Our Ref: B21169-L001  
 Planning Ref: **2015/62/93014/E**  
 Chkd: NDT  
 Date: 6<sup>th</sup> October 2017

**Re: Joseph Priestley Enterprise Centre**

Drawing No: **NG8230-101** Rev. **B**

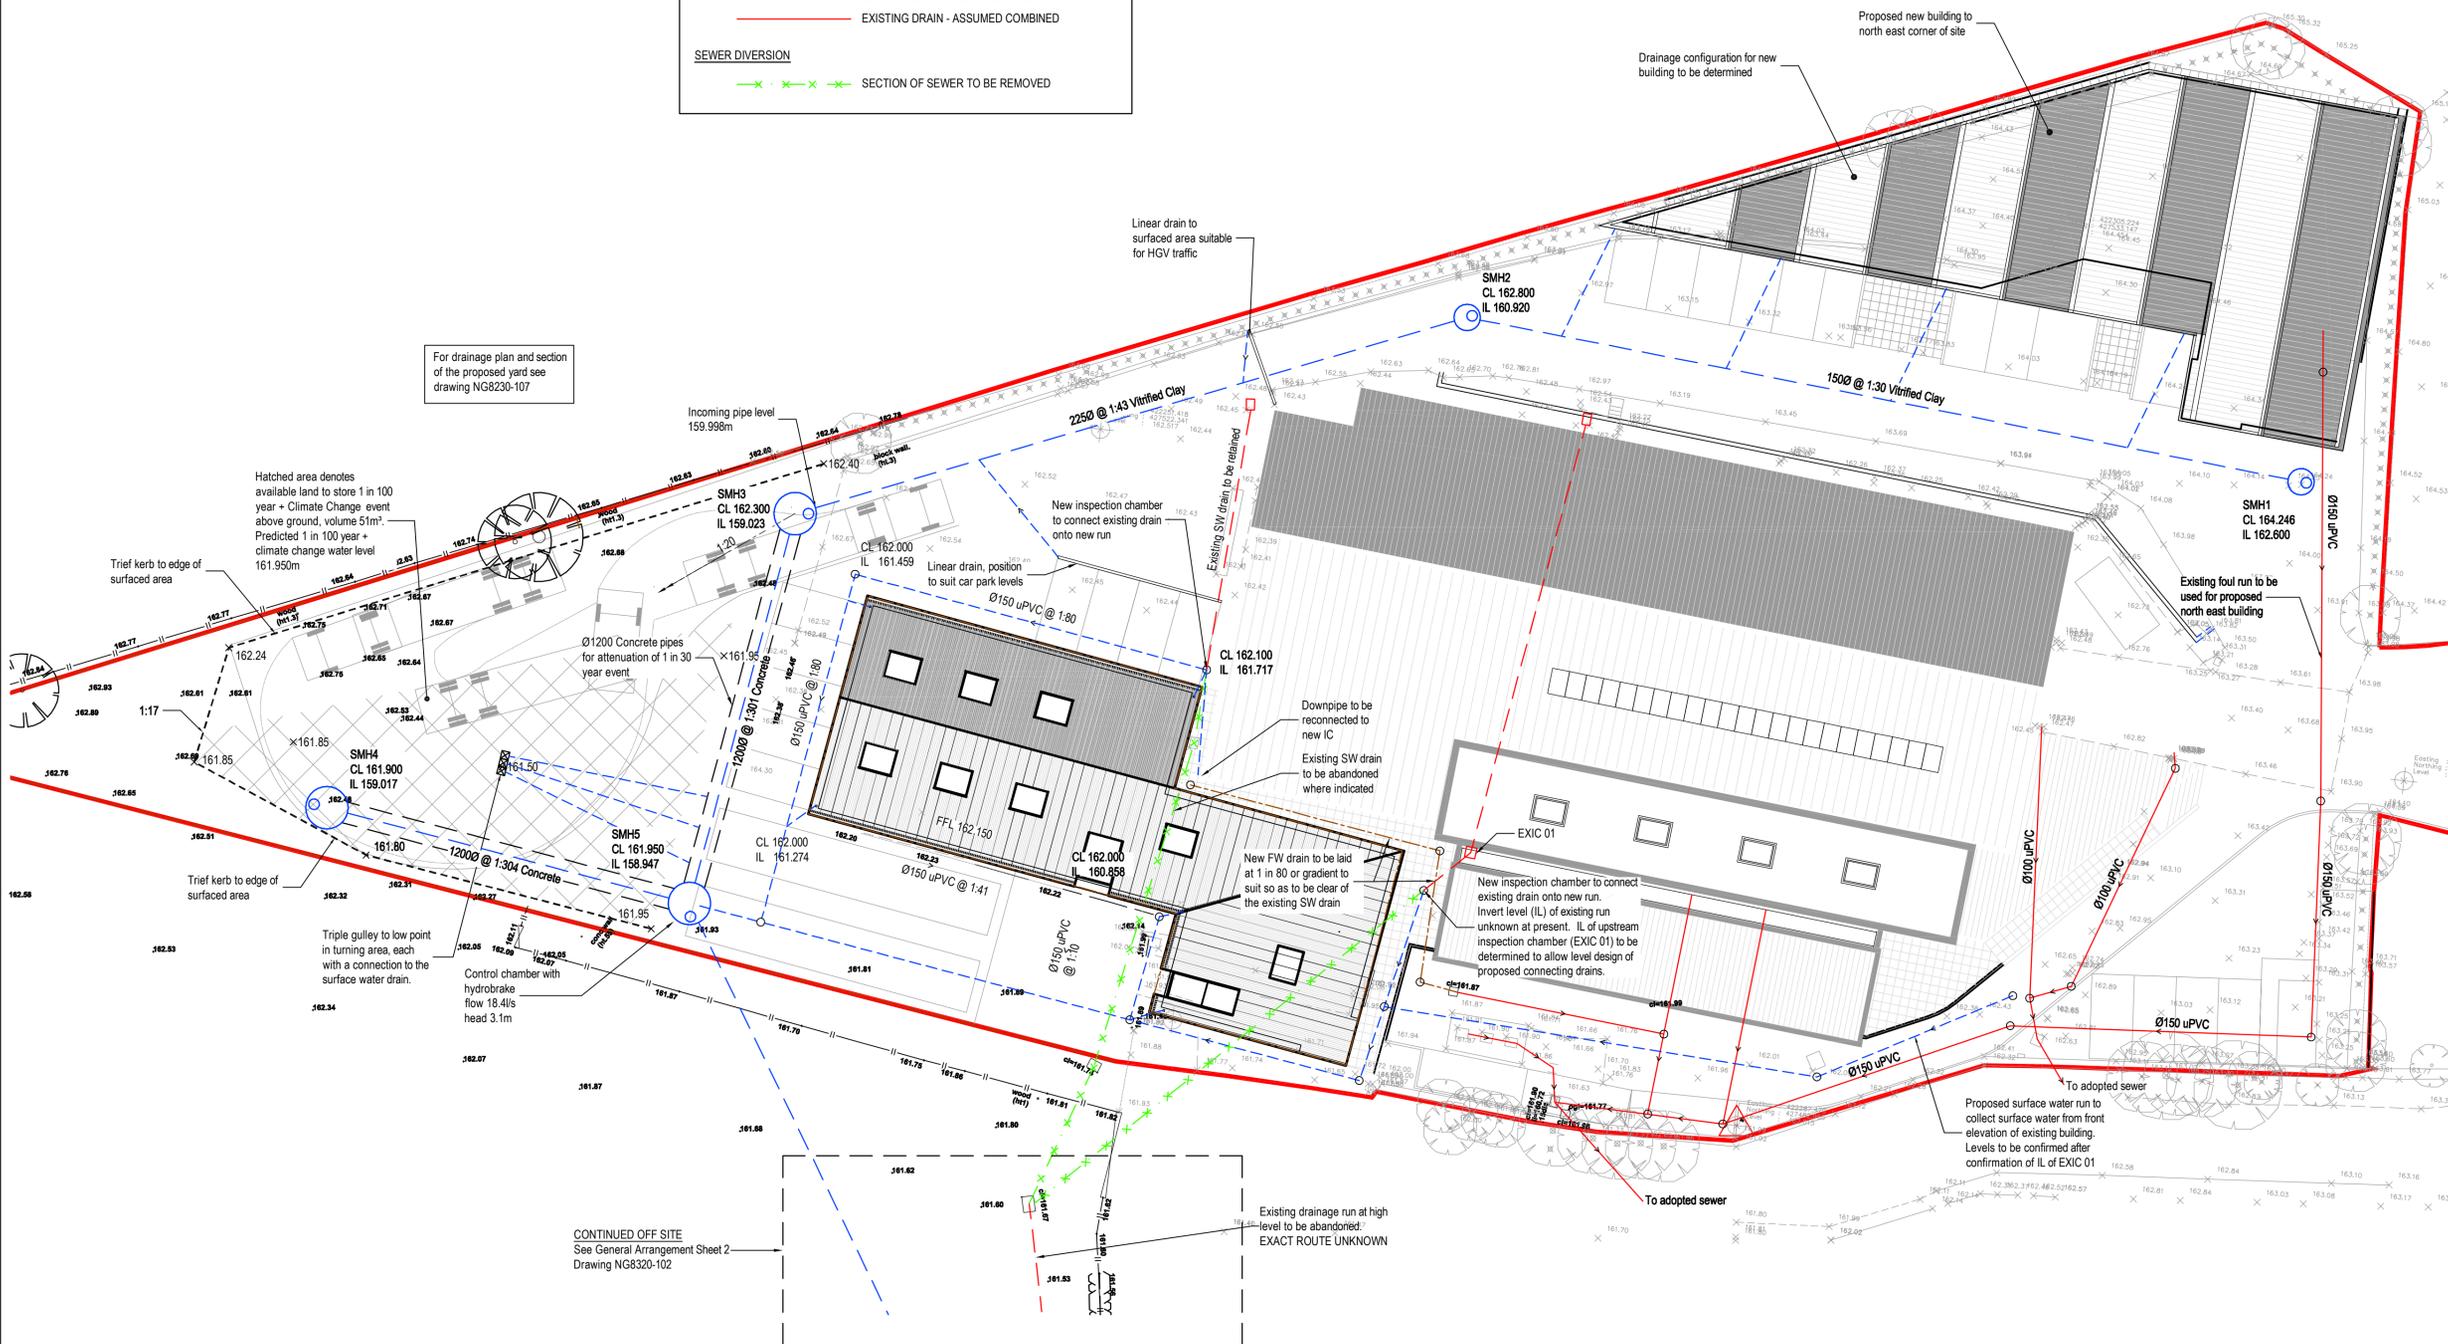
The original application showed surface water attenuation as oversized pipes. The new solution uses a crated tank system. The comparisons between the two proposals are outlined below:

The 1 in 30 year volume within the drainage system has been increased and so this does not cause any concern. The 1 in 100 year + climate change over ground storage is approximately 5m<sup>3</sup> less than the previous submission. The increased volume within the tank easily offsets this and so also causes no concern.

Drawing No. **B21169-SK01**

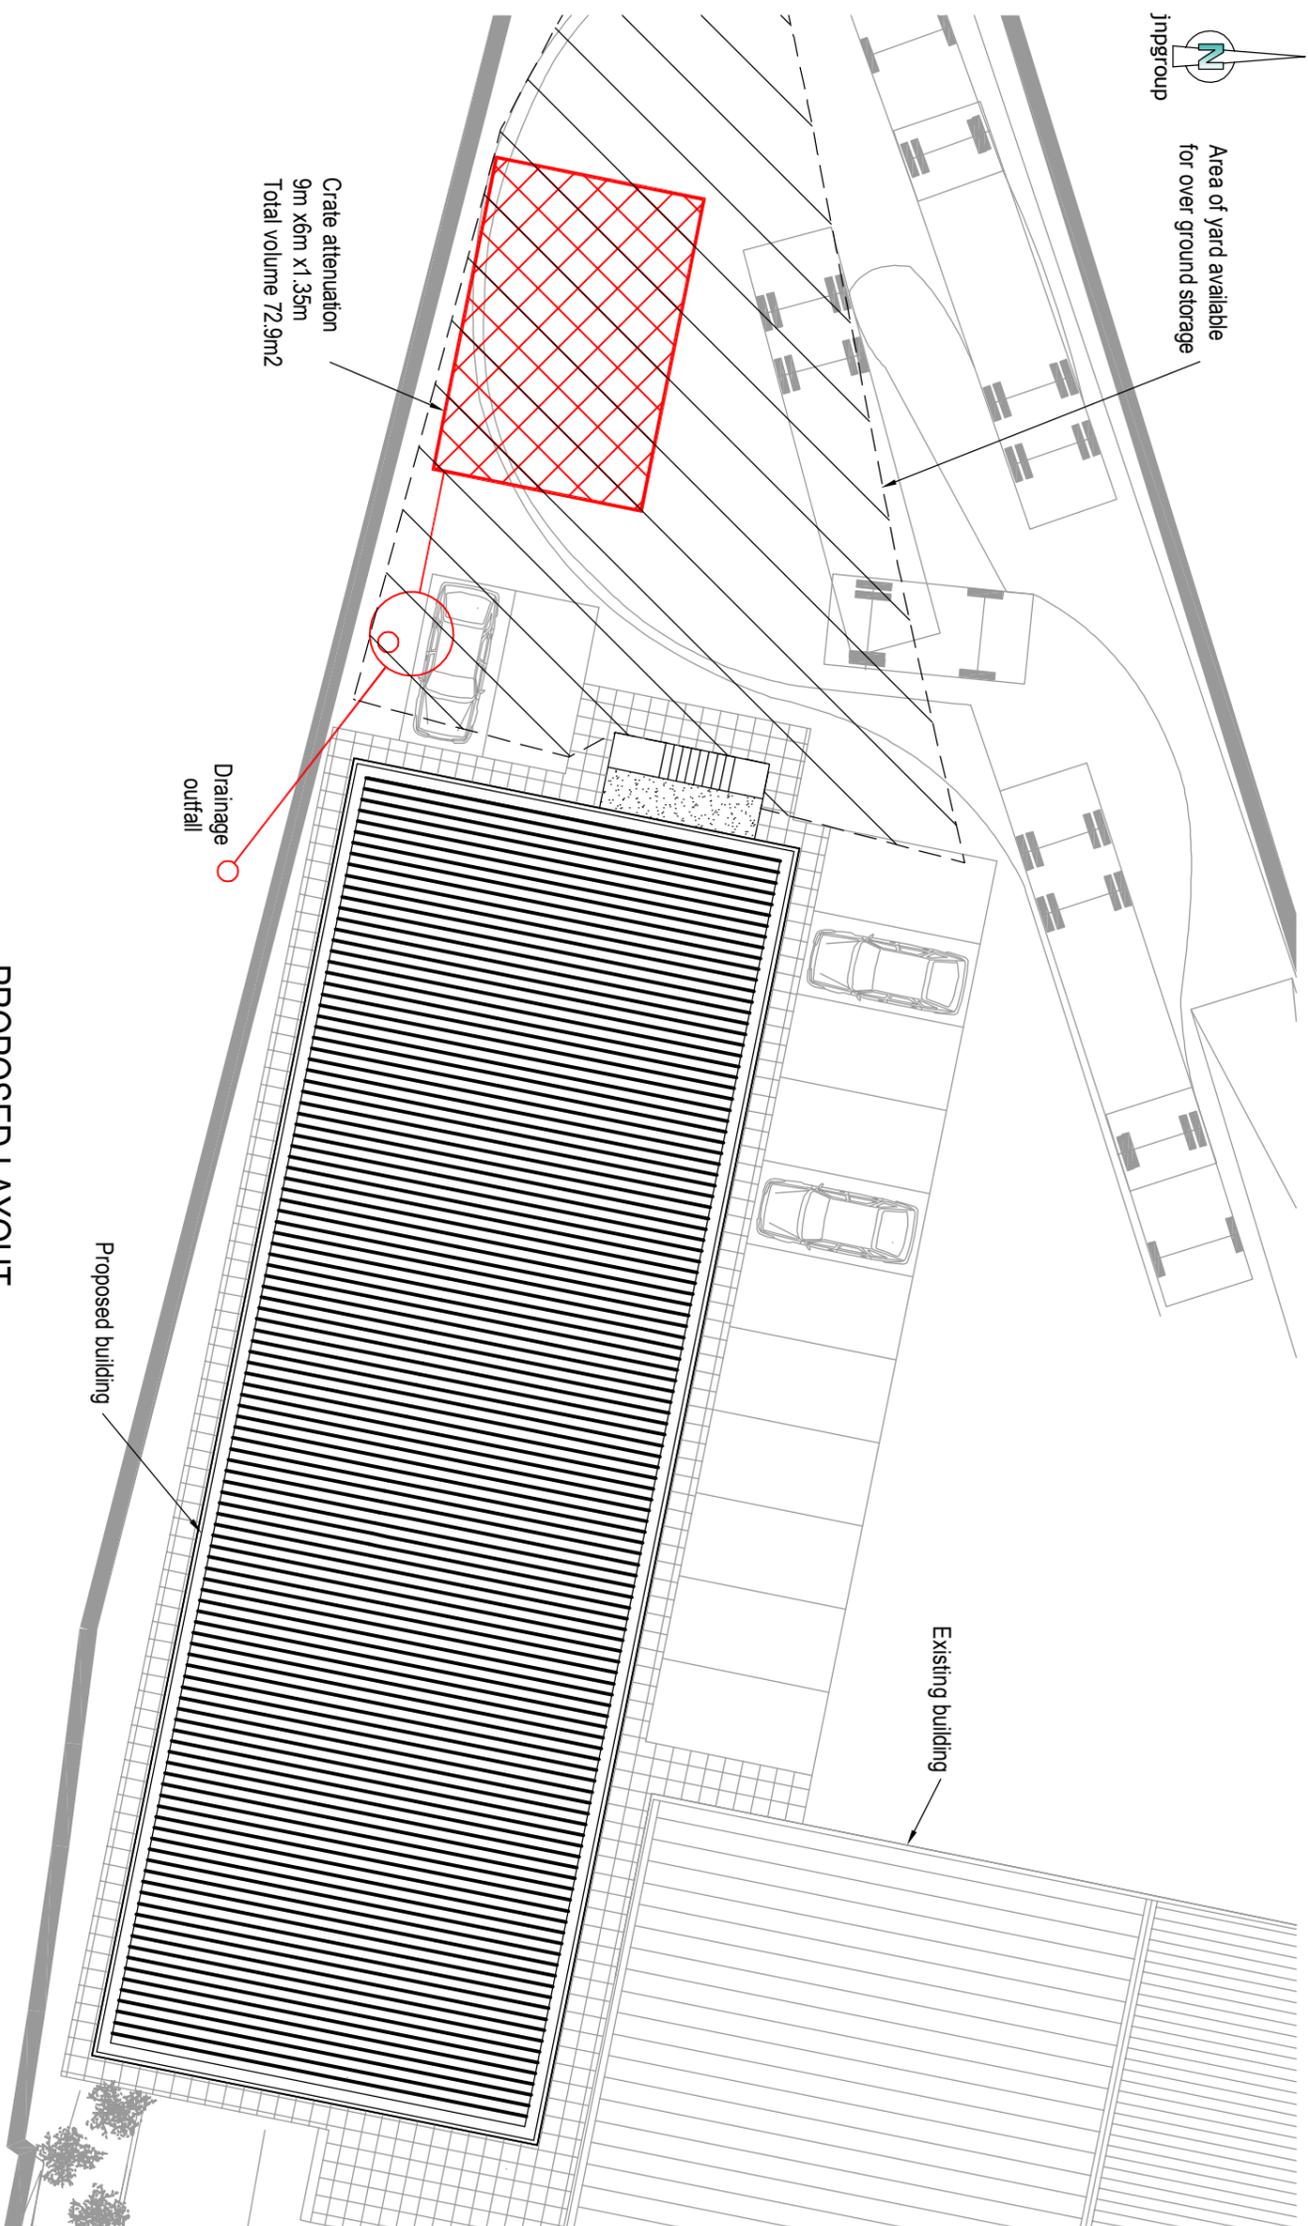
Planning Application	Attenuation Volume (m3)	Building Area (m2)	Storage area in External Yard Area (m2)
2013/91636 (old)	51	410	289
2015/62/93014/E (new)	72.9	481	284

The sizes and volumes above indicate that the drainage system using crates is an adequate replacement for the piped system originally proposed. The outfall agreed previously will remain the same, as will the drainage around the rest of the site.

Attached is a sketch showing the position of the crated tank which has been installed and the area of yard which will act as overland storage for the 1 in 100 year + climate change event.

It is of our opinion that the revised surface water system is adequate to deal with the volumes of water for the relevant rainfall events.
